APPROVED
 Limited building only review
 Permit holder responsible for full compliance with the code

TYPICAL MASONRY RETAINING WALL DIAGRAM

TYPICAL MASONRY RETAINING WALL DIAGRAM

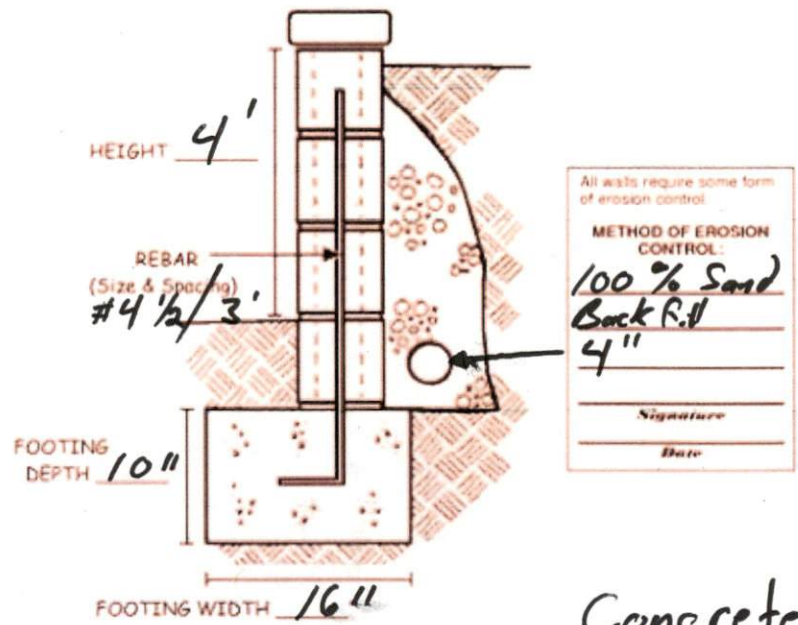
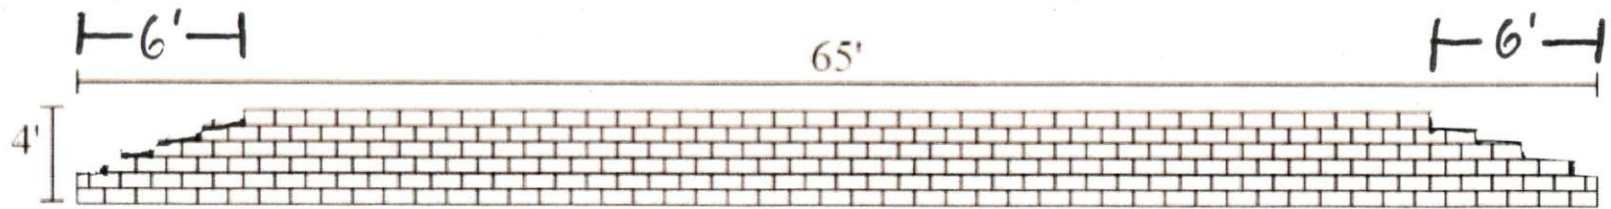
These walls may not exceed 4 feet in height, or they shall be designed by an NC Professional Engineer.

~~260.00~~ ft² Wall Area = 200

~~400.00~~ ft² Wall Area - 300
